From: David Easton
Sent: 08 February 2019 10:19
To: Karen Parsons
Subject: FW: Application 91/18/PL - Additional Information

David Easton | Principal Planning Officer, Arun District Council | Location: First Floor, Arun Civic Centre, Maltravers Road,
Littlehampton, BN17 5LF

Please find attached a copy of an overlay plan in respect of the proposed temporary building, that should hopefully provide sufficient clarification to demonstrate that access to the relevant inspection chambers and flow control chamber, as was the concern of the Drainage Officer.

Planning Application Drawings
Temporary Structure
Proposed Site Plan
1:500@A1

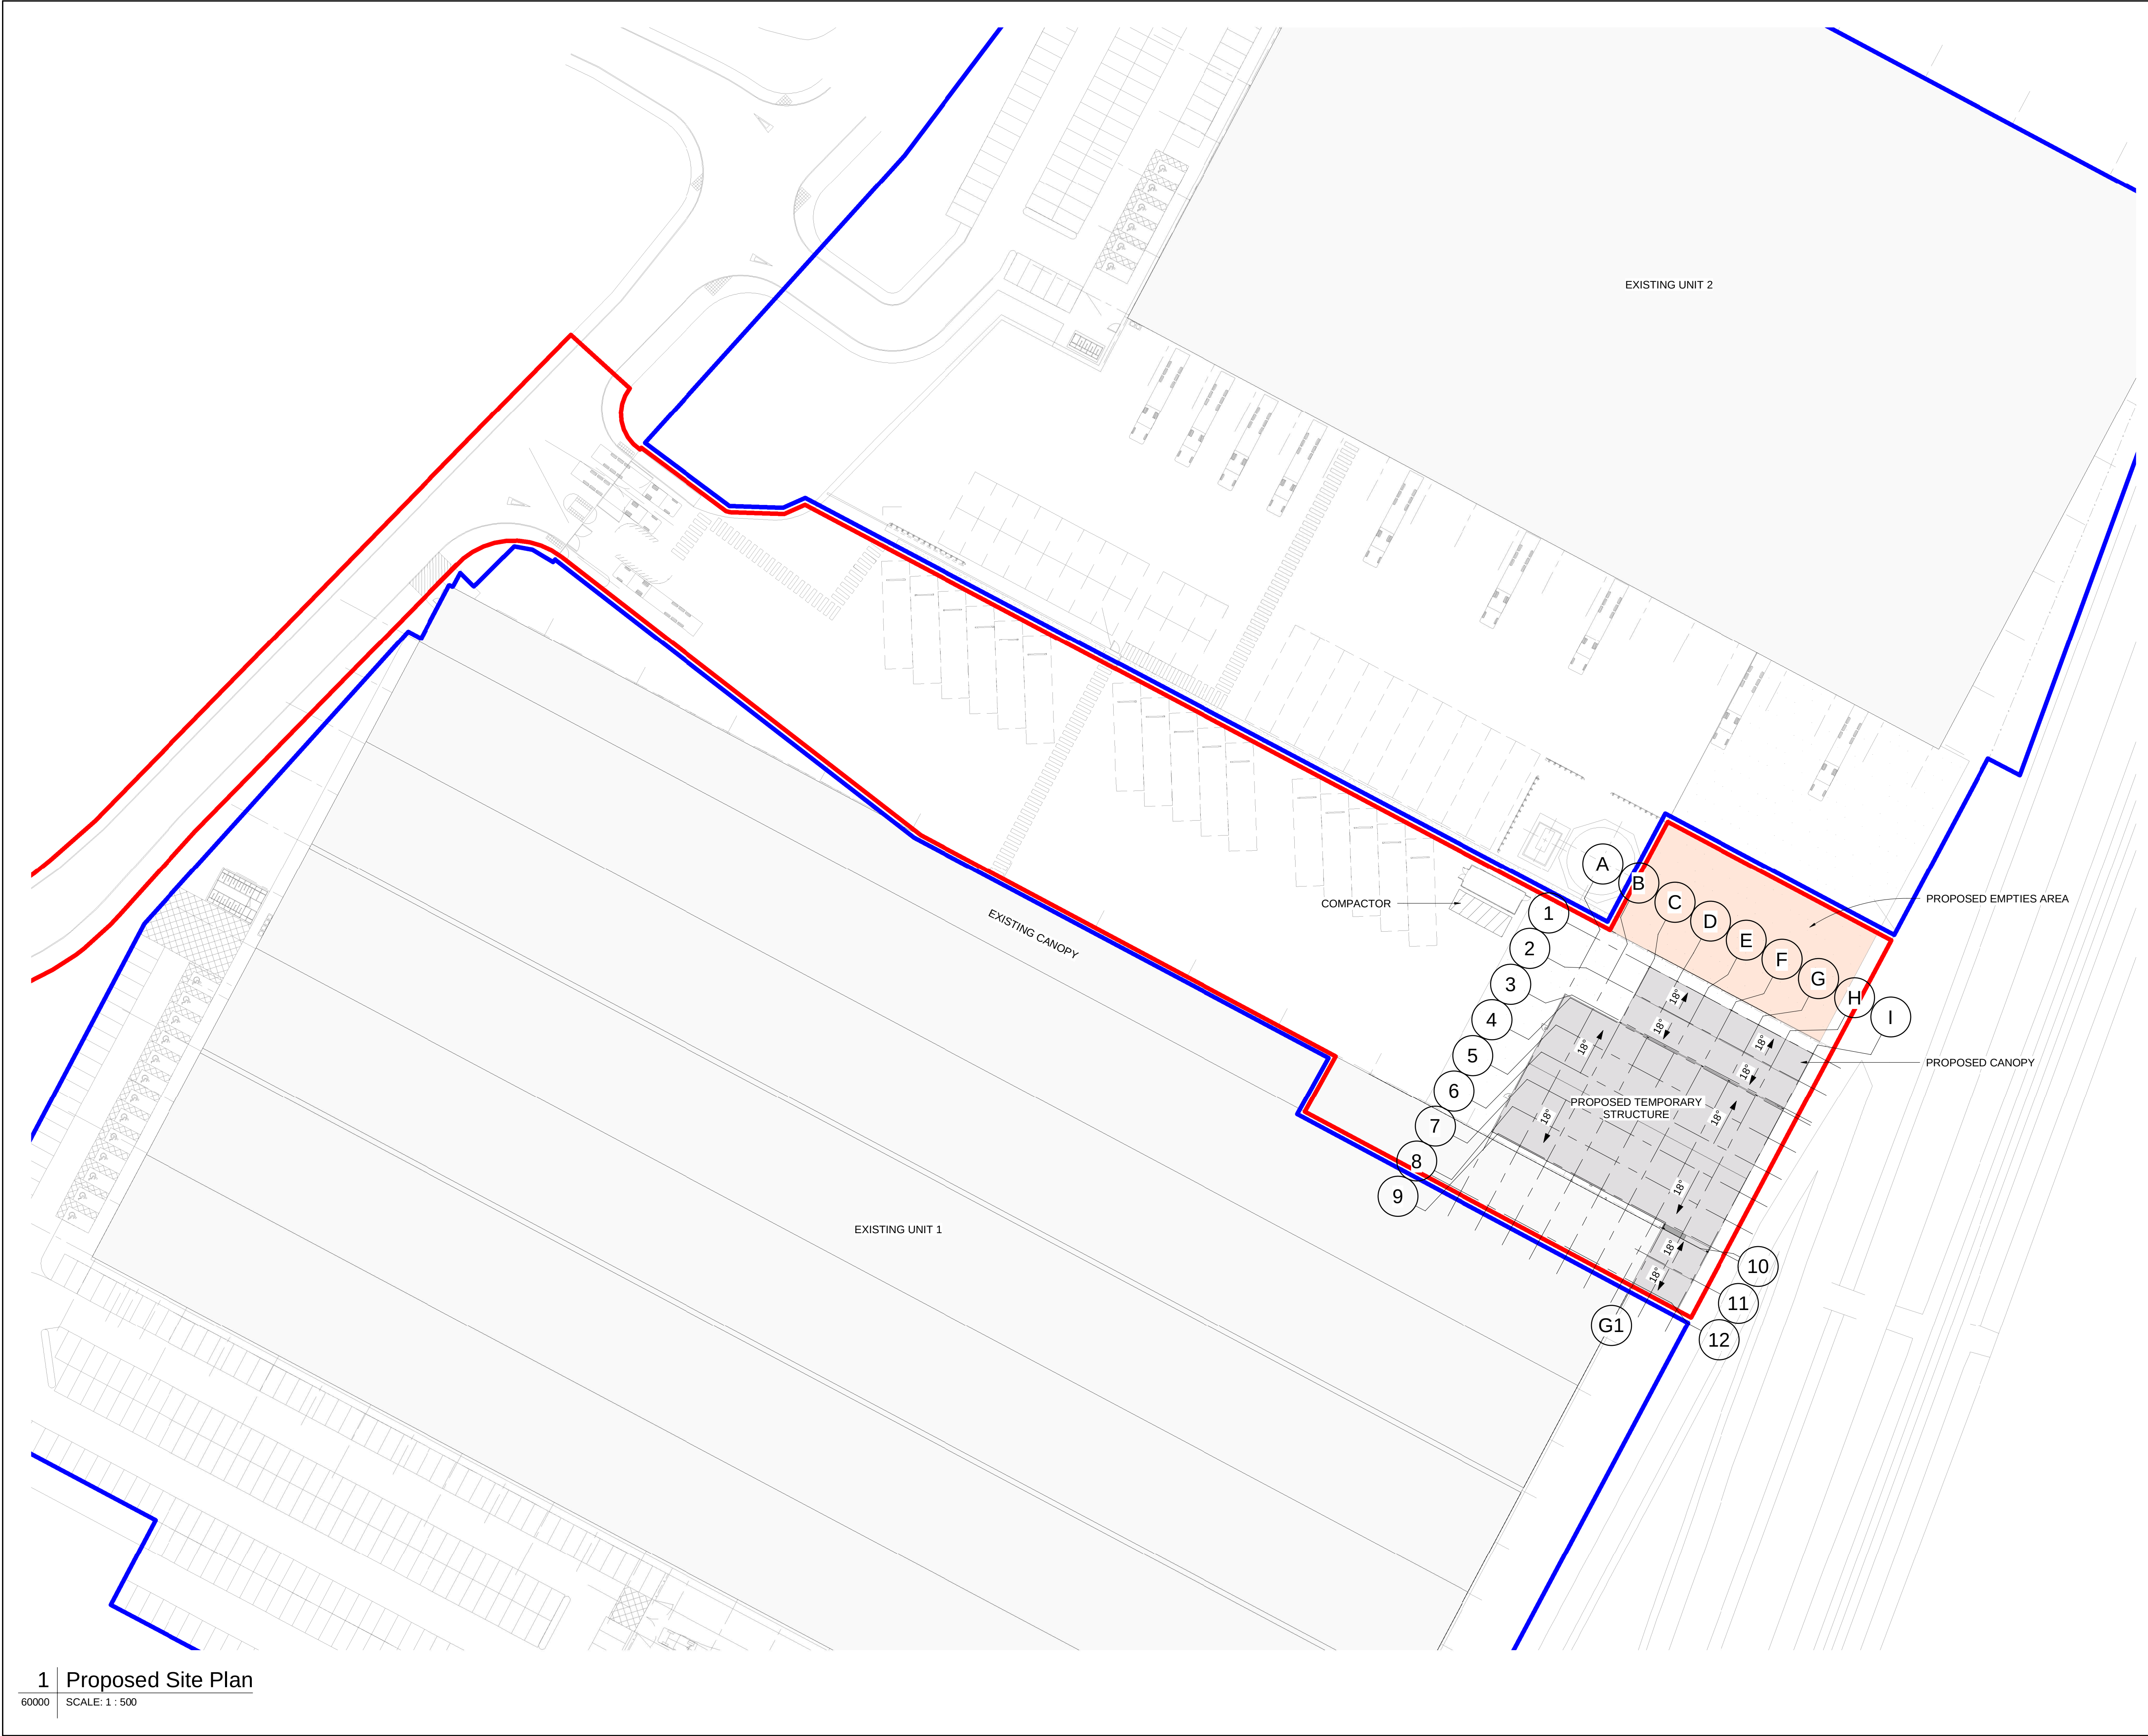
Having undertaken these discussions it is considered that the use of conditions as proposed is not appropriate. The proposed development is located above the existing surface water drainage network and even overlaps the circle used to identify the location of the flow control chamber. In the absence of as built drawings it is not possible to be certain that the proposed structure will not sit directly over access points to the surface water drainage network. This is important due to maintenance requirements with flow control chambers, attenuation tanks, separators and French drains all requiring regular maintenance. There are also likely to be further inspection points and vents on the attenuation tank.

It is also worth noting that the proposed structure will be located directly on top of the attenuation tank and without assurances as to the loadings we cannot be confident that this will not result in damage to the tanks.

The details provided are insufficient to demonstrate that maintenance of the suds can occur and that loading upon the attenuation tanks is acceptable.

- As built survey drawings of the surface water drainage;
- Written commentary for the methodology for maintenance of the SuDS; and
- Structural drawings and calculations for the proposed structure.

The drawing shared demonstrates that the proposed development and its location is compatible with the approved drainage layout and scheme, and does not prevent access to the inspection chambers. Whilst I appreciate that this is not an "as built" survey drawing – the drainage layout is an approved scheme and one already secured through condition for the existing development, and therefore demonstrates (in principle) that access for maintenance to the SuDS can be retained. We would question the necessity of providing additional detail for planning purposes at this stage.

It would not be possible to provide precise details of the structural loading and calculations until detailed construction drawings are available (the submitted drawings are relevant for planning), which cannot be undertaken until a contractor has been appointed. Similarly, it would be premature at this stage to provide details of the methodology of the maintenance at this time, other than to confirm that access will be maintained and permitted to the SuDS, as required. Again, we feel that both could be satisfactorily secured through a suitably worded condition.
